10th December 2020

**Objections to the planning application for the
erection of detached dwelling with integral garage
at Springwood House, Sheffield Road, New Mill HD9 7EX**

SECTION A-A

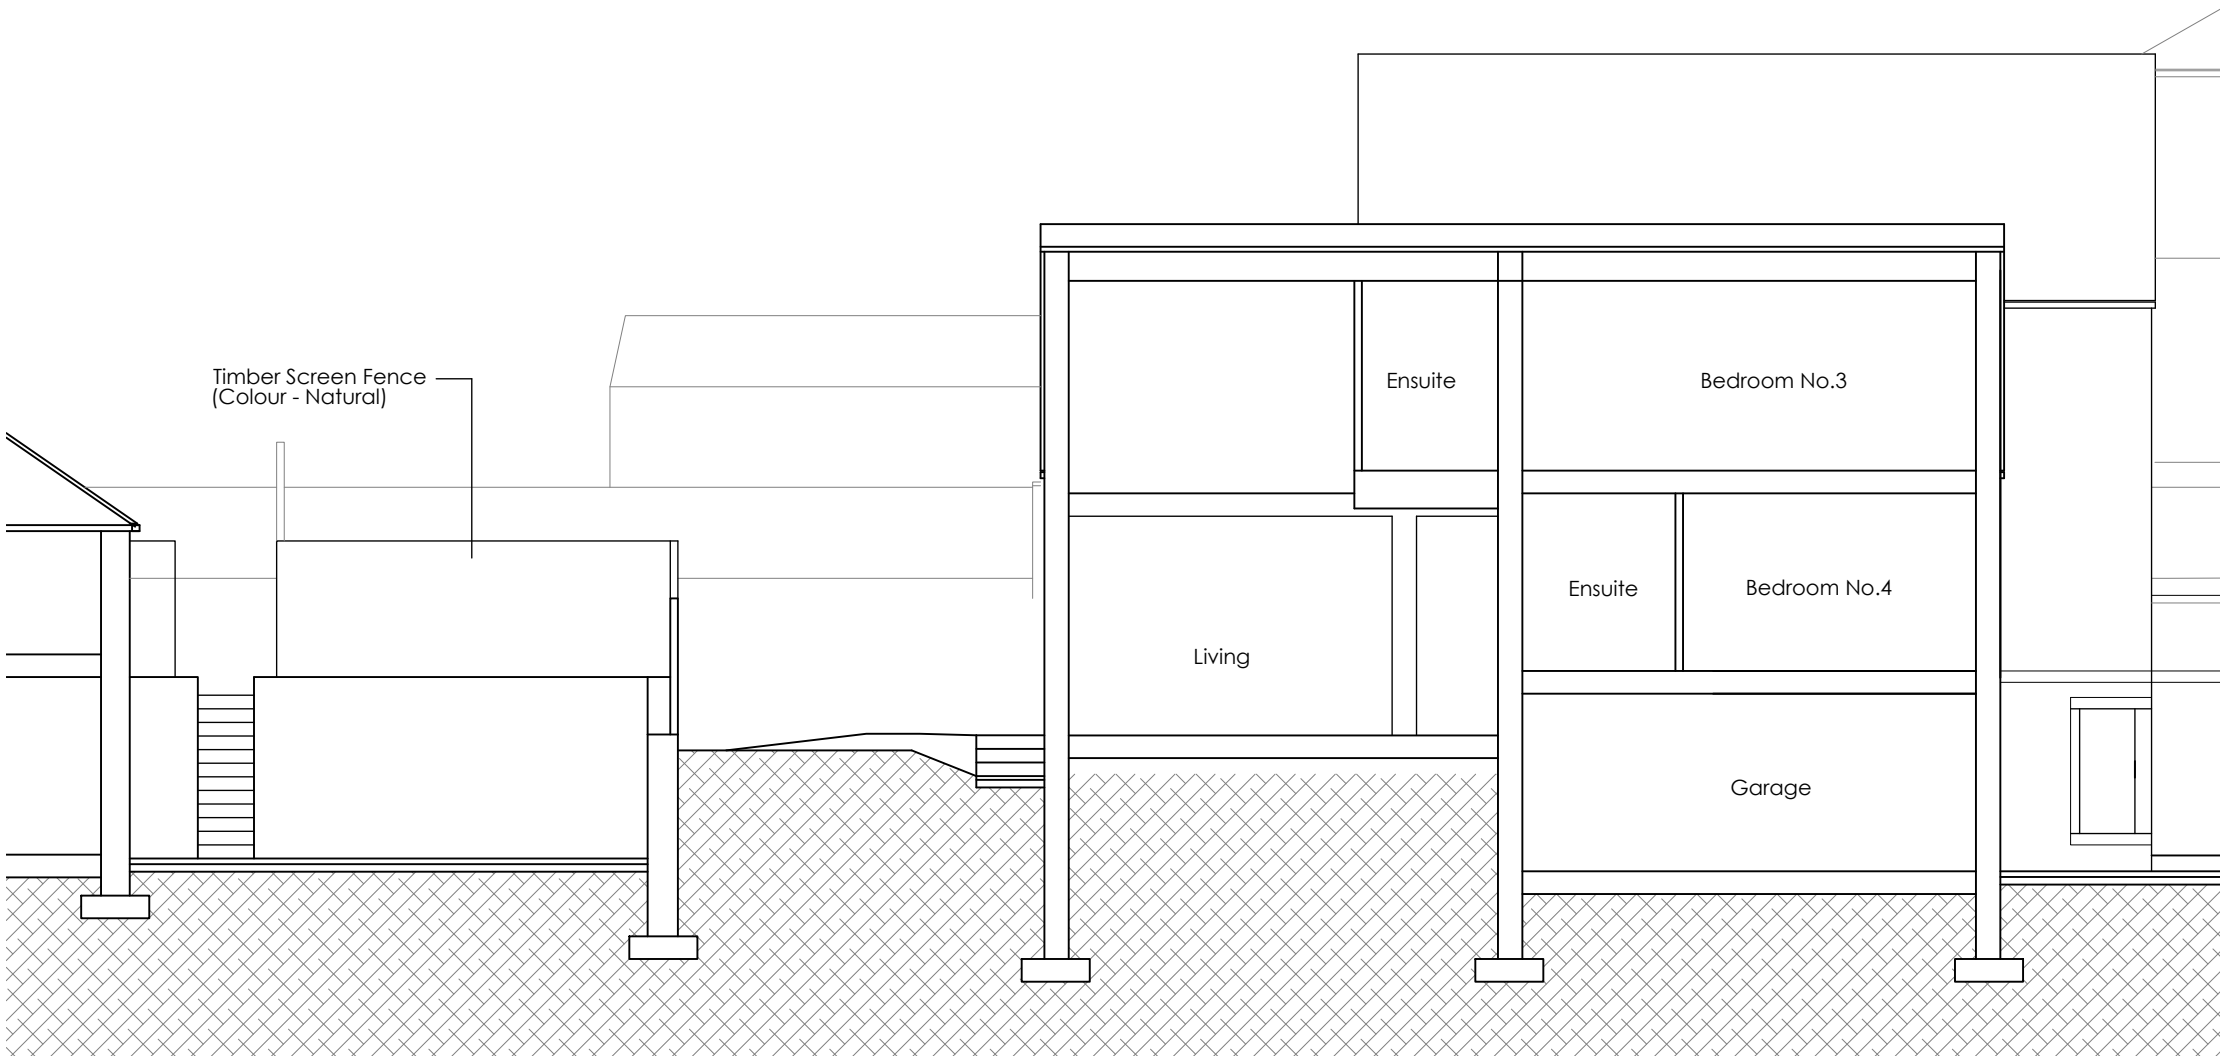
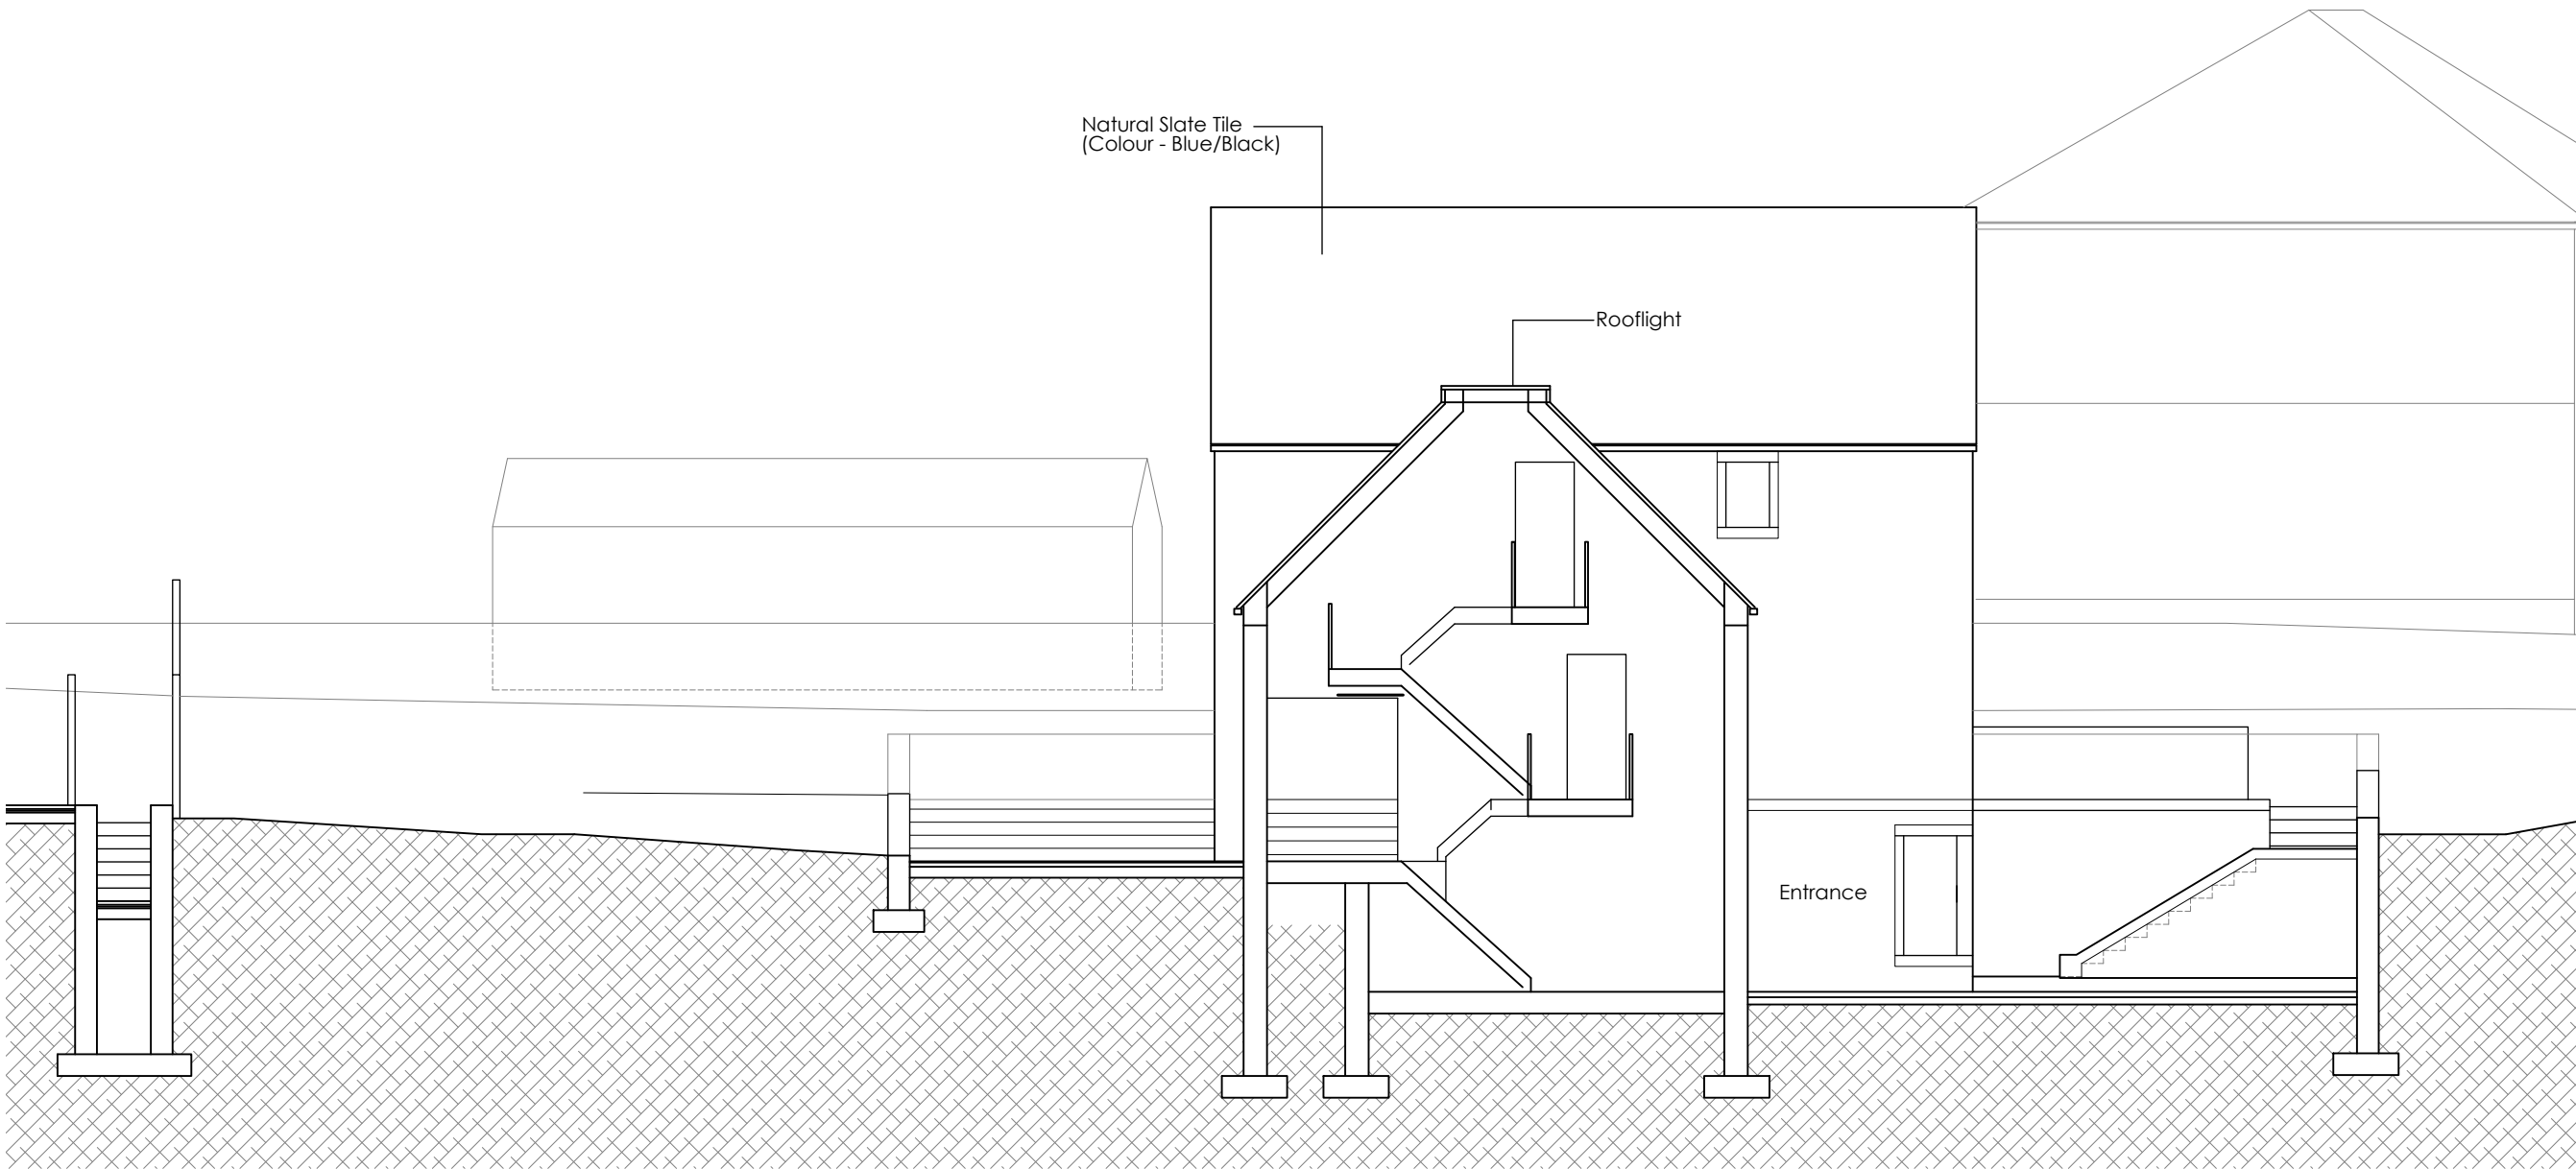
4. CHARACTER OF THE NEW BUILD
Springwood House and The Coach House share a history and the new house will sit in close proximity (around 6 8 meters) to both. Therefore it would be best if it were to look like it fit in. The style of the plans are for a 3 story house with large arched windows and lots of levels, will in my opinion, overpower, dominate and distract from what is a lovely, simple, period setting.

5. HEIGHT OF THE NEW BUILD
I am concerned that the height of the new build will block the sun from the front of The Coach House, which as I've stated is where 90% of my windows are. Trees block sun to the East and Springwood House to the West, so I think this could have a significant effect on the light levels in my home. And also from my garden and vegetable patch.
